Recommendation Report for Works to Tree(s) on trees subject to a Tree Preservation Order (TPO)

**REF NO:** FG/217/21/T

**LOCATION:** 1 Sea Lane Close  
Ferring  
BN12 5DT

**PROPOSAL:** 1 No. Macracarpa tree (T1)- Remove damaged major lower N/E limb back to trunk. Reduce lower northern limb by 3m to give adequate distance from highway. Reduce radial spread by 2m, reduce overall spread from 14m to 10m. Crown lift to 5m. Deadwood canopy and remove any damaged branches.

T1

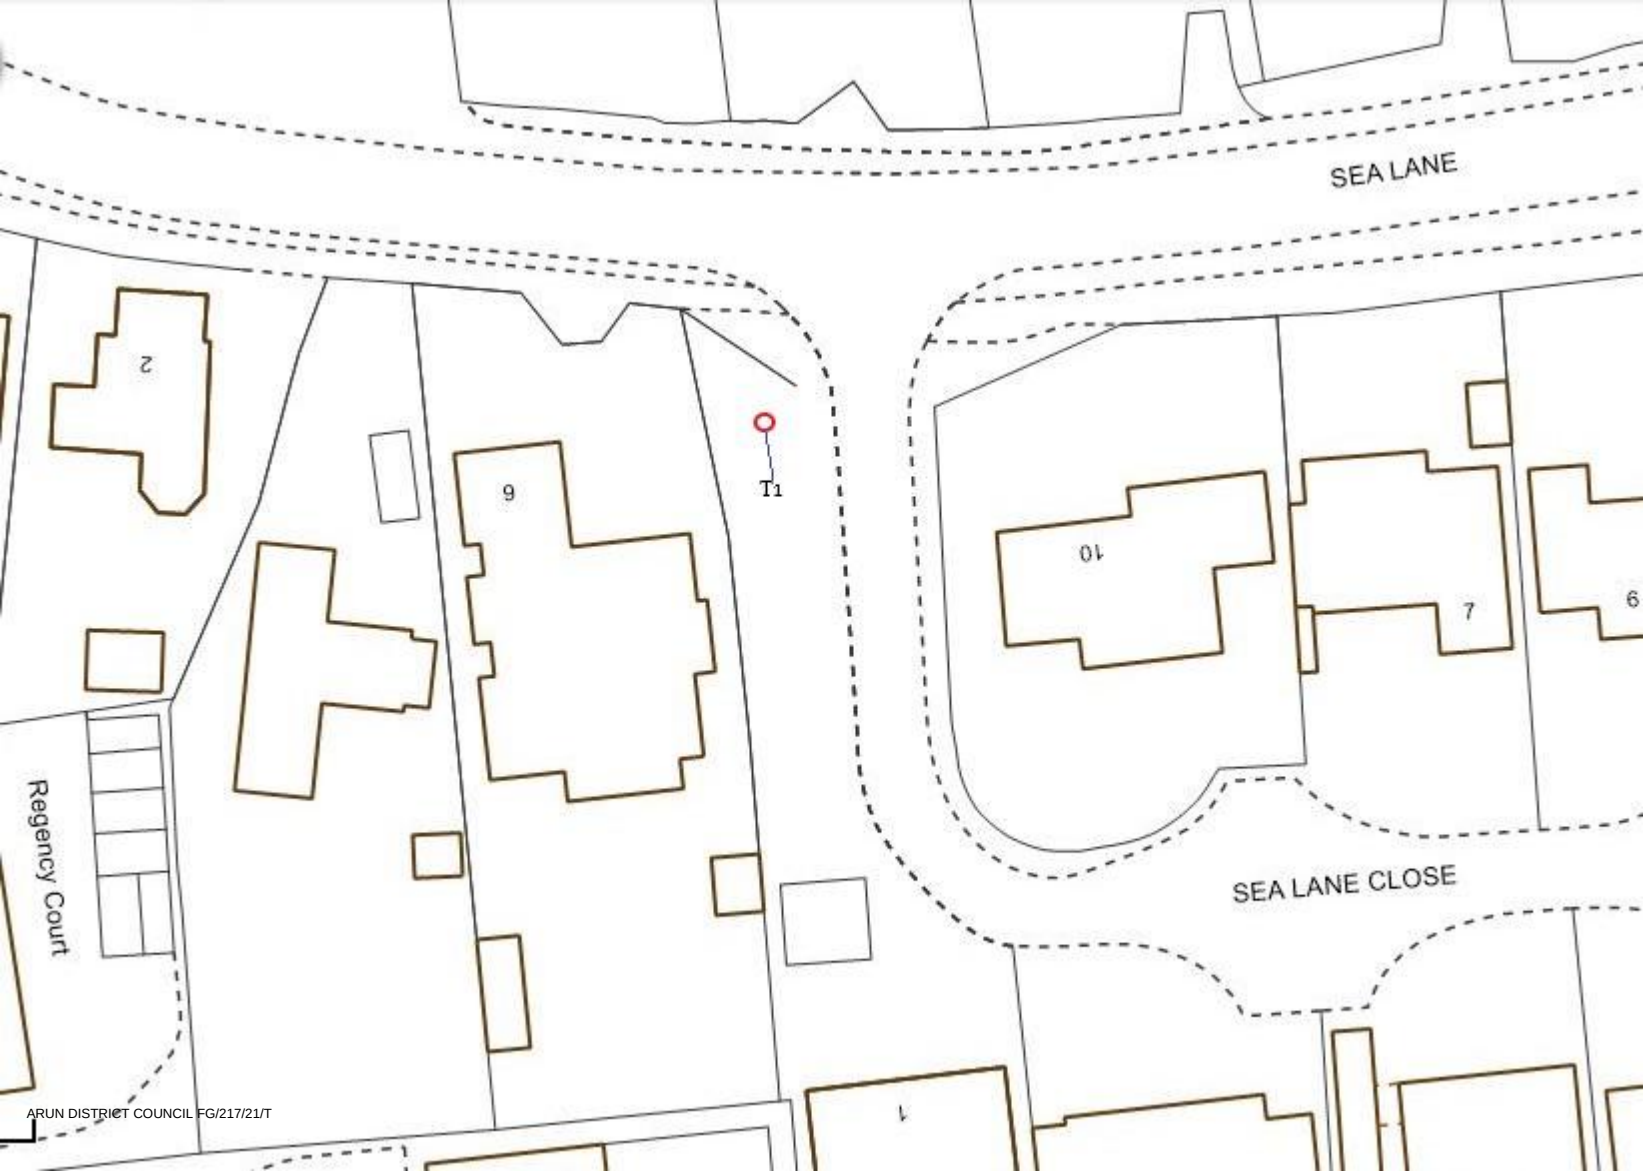
The Parish Council agrees with reducing radial spread to north by 2m but not to reducing overall spread from 14m to 10m that would be damaging to tree. Crown lift to 5 is excessive and 3 to 4m would be acceptable. Removing deadwood and dangerous branches can normally be carried out without permission. In summary, Ferring Parish Council objects to this application and to the reducing of overall crown spread and crown lifting to 5m as being excessive and damaging.

- The removal of low branches to achieve 5m clearance above ground level on all aspects has not been justified on arboricultural grounds and exceeds that which is recommended in the British Standard

- Adequate clearance of public highway and removal of hazardous material can be achieved by undertaking limited works under the exception that the removal of dead or imminently dangerous branches (such as those that are longitudinally split through - 'hazard beam') does not require planning consent, although in respect of the latter those undertaking are required to notify this authority at the earliest opportunity

- Whole crown reduction pruning has not been justified on arboricultural grounds in my opinion. The extent of property and public highway overhang is not obviously problematic where adequate overhead clearance exists and it contributes to visual amenity.

- The tree is a significant feature in the local landscape and appears to be in adequately sound and healthy condition. Elements of tree surgery within the proposal that do not qualify as an exception would result in excessive reduction of the tree's landscape impact and undue detriment to the visual amenities of the locality.

- 1 The tree appears to be in an adequately sound and healthy condition. Elements of the proposed works result in the excessive reduction of the tree's landscape impact and undue detriment to the visual amenities of the locality.
